**WELWYN HATFIELD BOROUGH COUNCIL
DIRECTORATE OF STRATEGY AND DEVELOPMENT**

DELEGATED APPLICATION

Application No: 6/2016/0739/HOUSE
Location: 56 Bluebell Way, Hatfield, AL10 9FJ
Proposal: Conversion of garage
Officer: Ms L Hale

6/2016/0739/HOUSE

Drawing title:
 House extension
 Ground floor plan
 New proposal

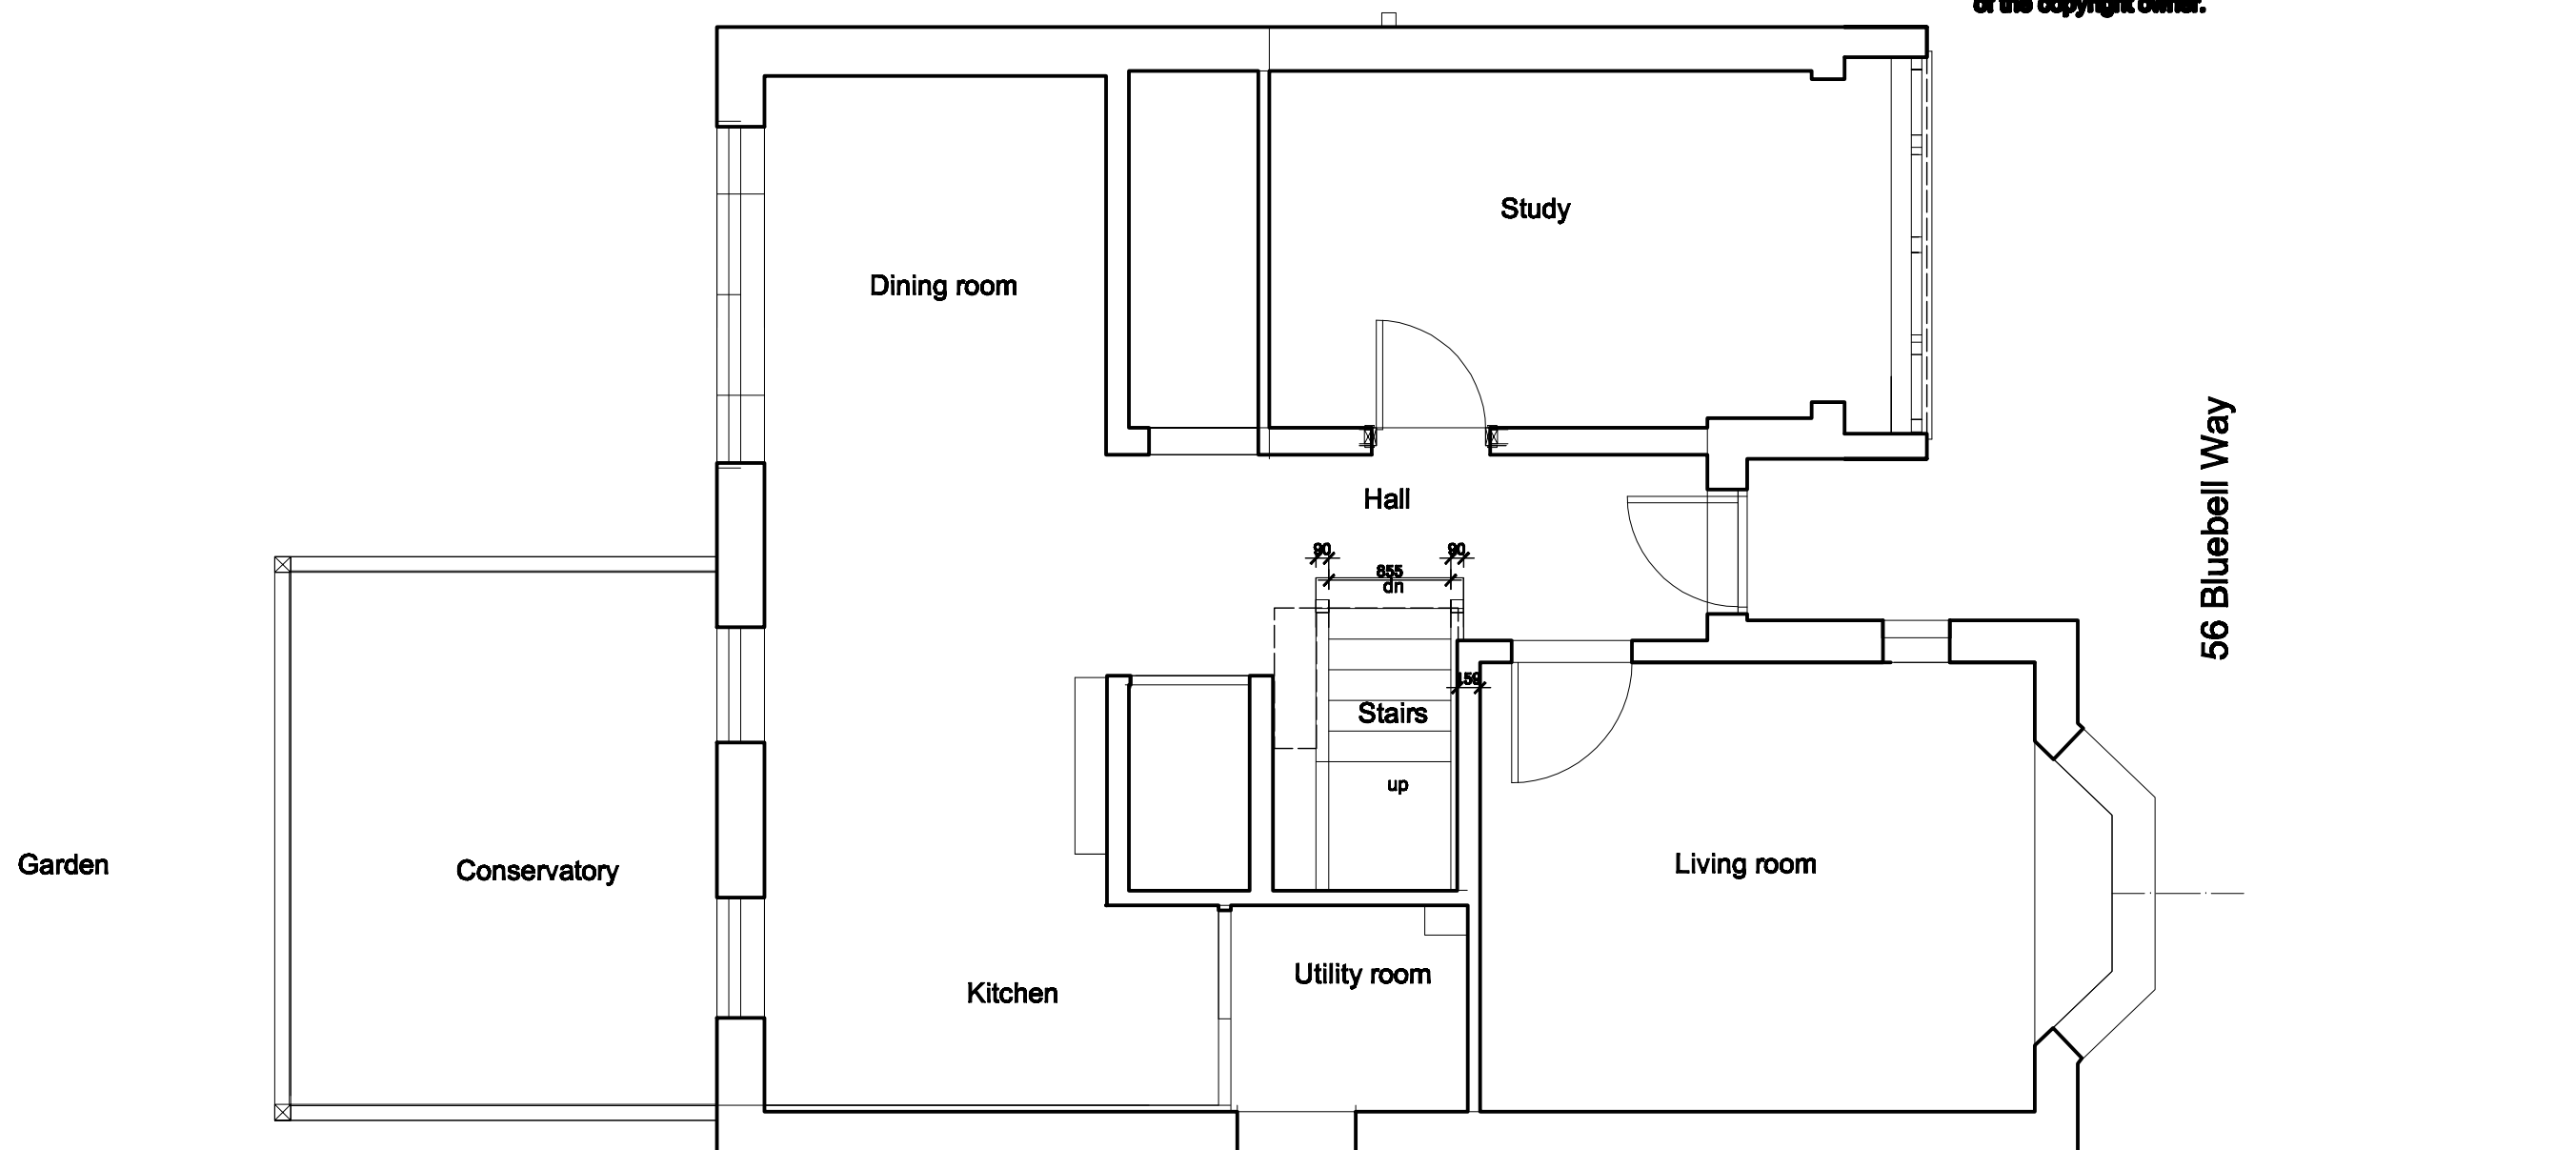
The proposed garage conversion would also involve the extension to the front elevation of approximately 0.5 metres. Given the separation distance and nature of the proposal, the development is not considered to have a detrimental impact on the living conditions of either neighbouring occupier in relation to overlooking, sun/daylight/outlook or privacy.

The proposal would result in the conversion of the existing garage, which would result in the loss of one parking space. However, the parking will be retained in front of the garage for approximately three vehicles and additionally the site benefits from on-street parking. With regards to garages, the Interim Policy acknowledges that many existing garages are too small for their intended purpose for parking/storing vehicles. For garages to have a genuine ability to be used for their intended purpose, they should be at least 6 metres long by 3 metres wide and sufficiently tall to accommodate modern cars. In this case the existing garage measures approximately 3.8 metres long by 2.5 metres wide, and therefore does not meet the minimum dimensions for the ability to be used for its intended purpose.
